**STATE OF WASHINGTON
DEPARTMENT OF ECOLOGY**

May 10, 2023

RE: 202301967, VA-23-00003

Thank you for the opportunity to comment on the Mitigated Notice of Application for the Sparks Park Variance, Easton Truck Stop. We have reviewed the application and have the following comment.

PRELIMINARY SITE PLAN
 MOUNTVIEW GROUP LLC TRAVEL CENTER
 WEST SPARKS ROAD
 EASTON, WASHINGTON

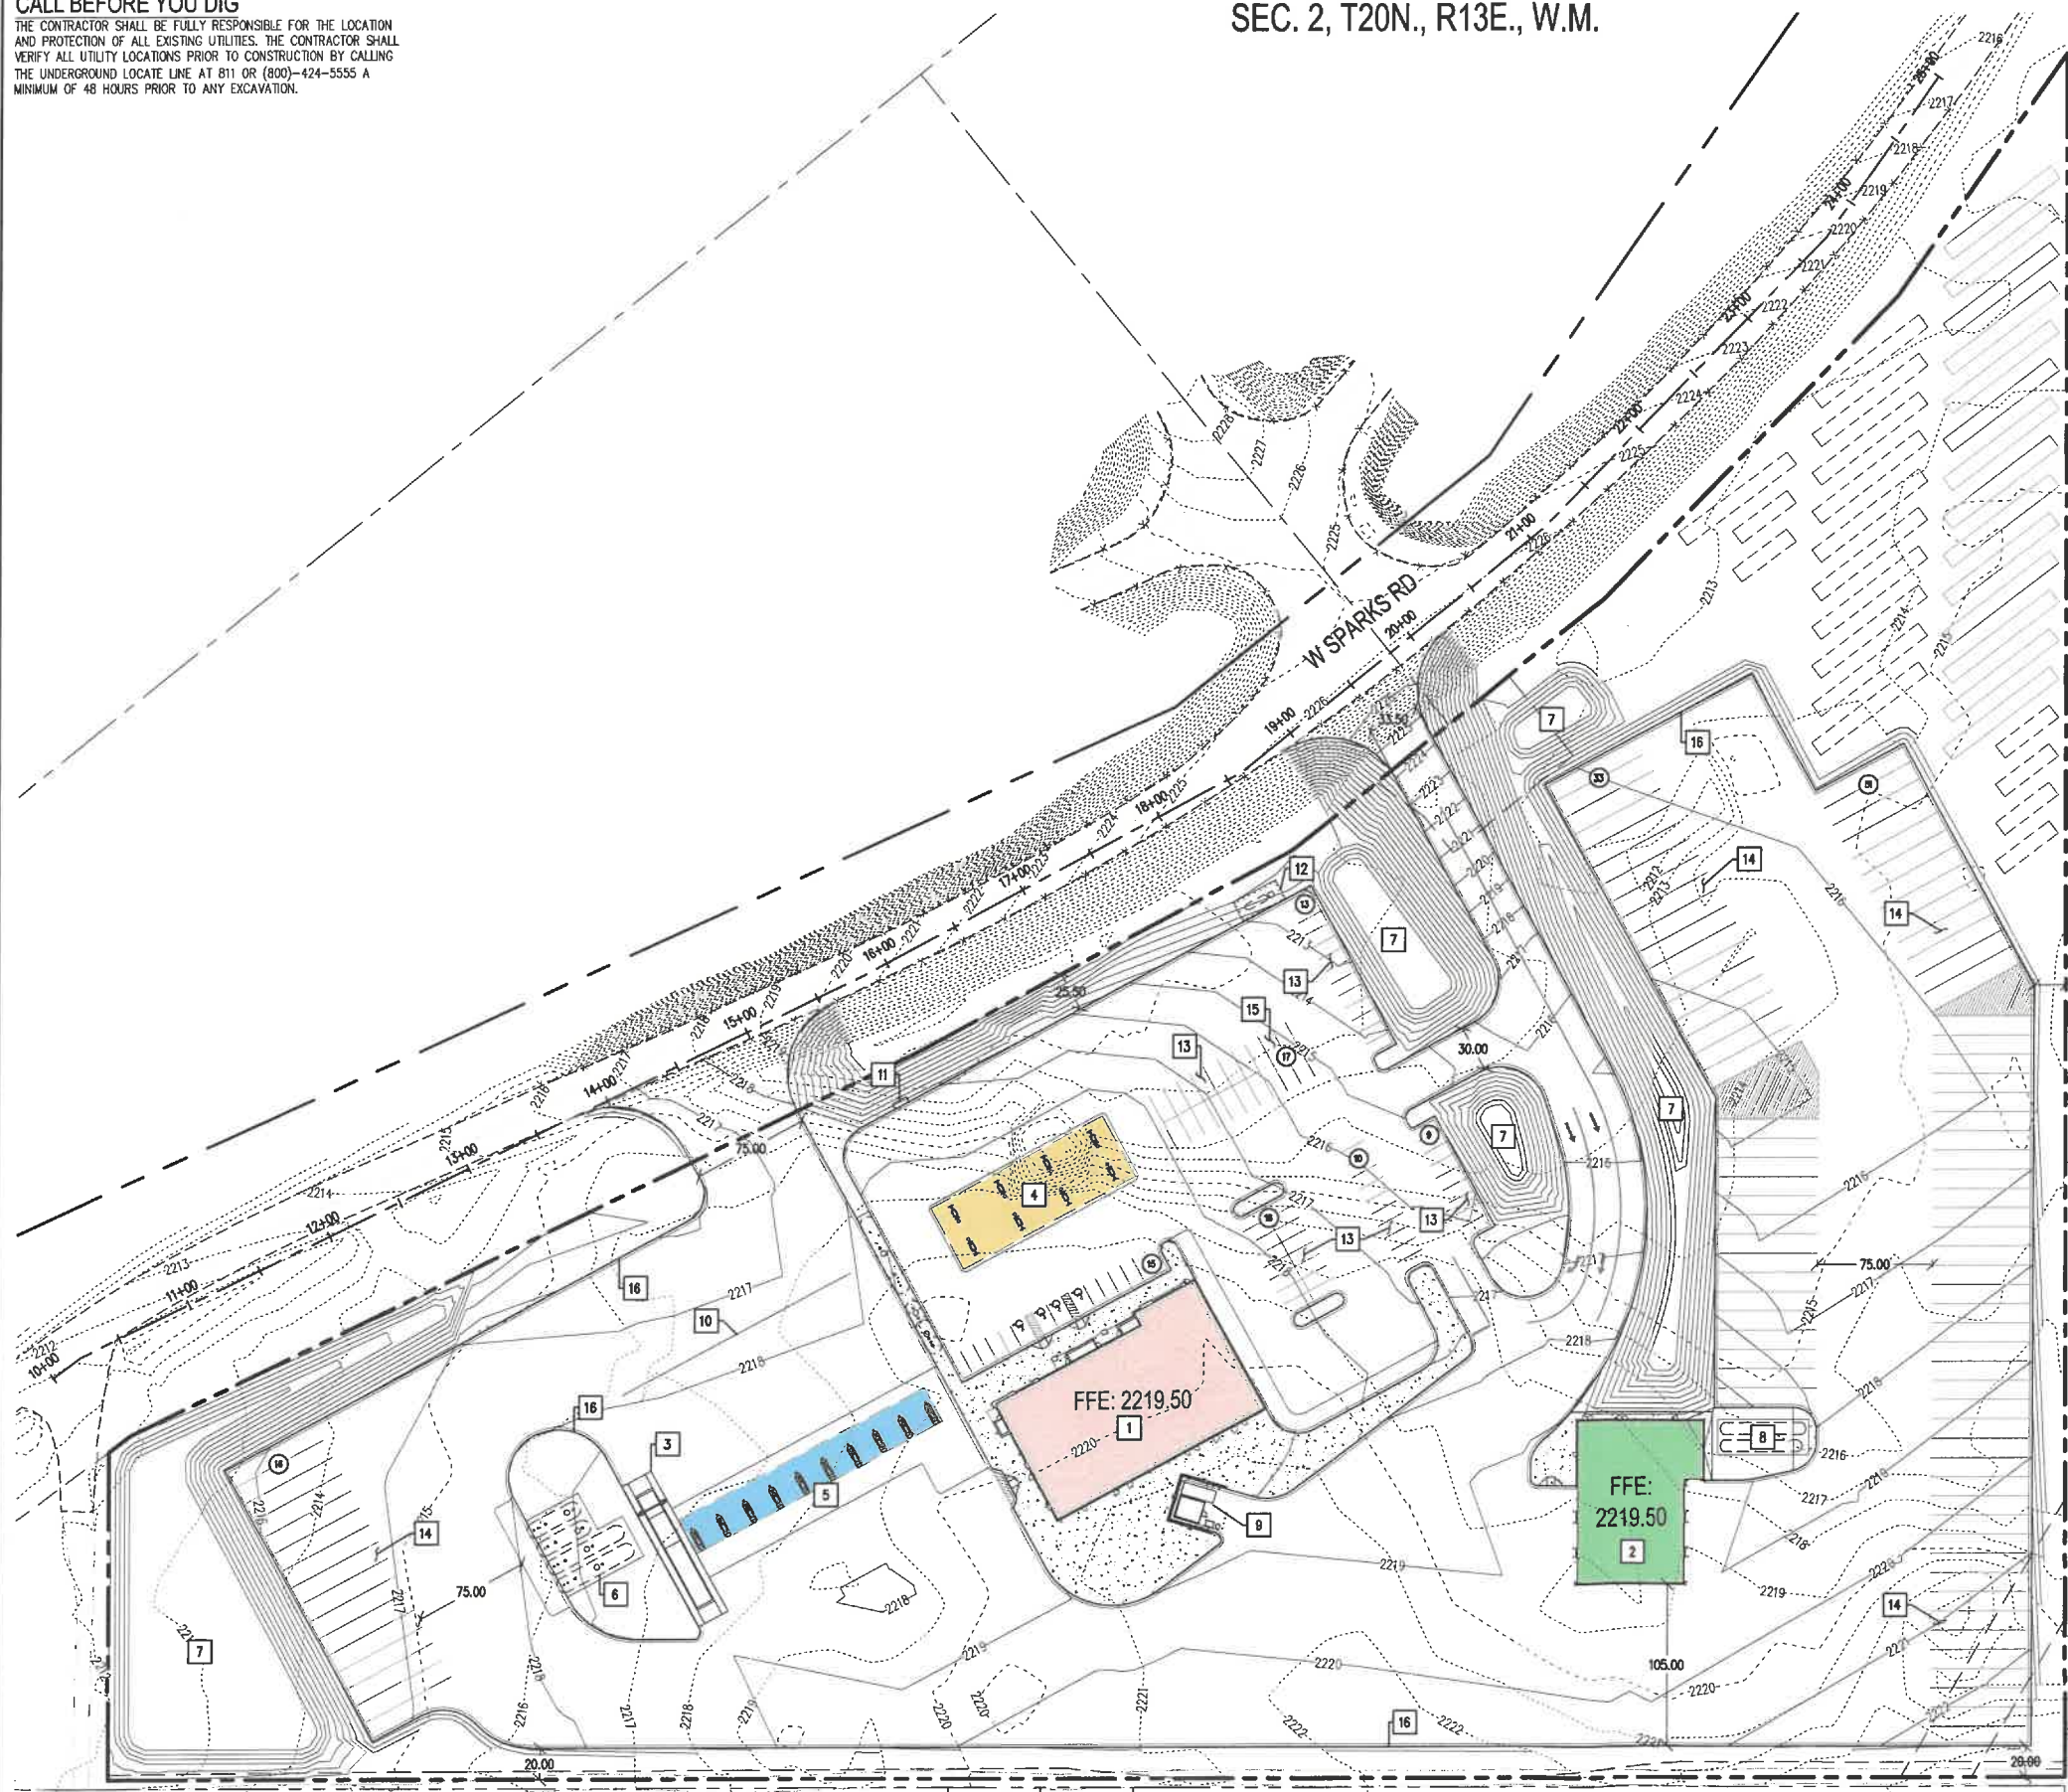
Installation of new underground storage tanks must meet the requirements of the state underground storage tank regulations (Chapter 173-360A WAC). All new tanks and piping must have double-wall

construction and be interstitially monitored for releases. Copies of these regulations and required forms are available from the Department of Ecology by calling (360) 407-7270 or toll-free in state 1-800-826-7716.

A notice of intent to install tanks must be filed with Ecology at least 30 days prior to installation. Within 30 days after coming into service, the tanks must be registered with the Department of Revenue's Business License Service on a state notification form. <https://dor.wa.gov/sites/default/files/2022-02/700041.pdf>

New tanks and any connected piping must be protected from corrosion by either a cathodic protection system, or by being constructed or coated with a non-corrosive material such as fiberglass. An acceptable method of leak detection must be employed, and the tanks must be equipped with spill prevention and overfill protection equipment.

Stage I vapor recovery equipment is required on all new gasoline dispensing facilities with a total gasoline nominal storage capacity greater than 10,000 gallons.
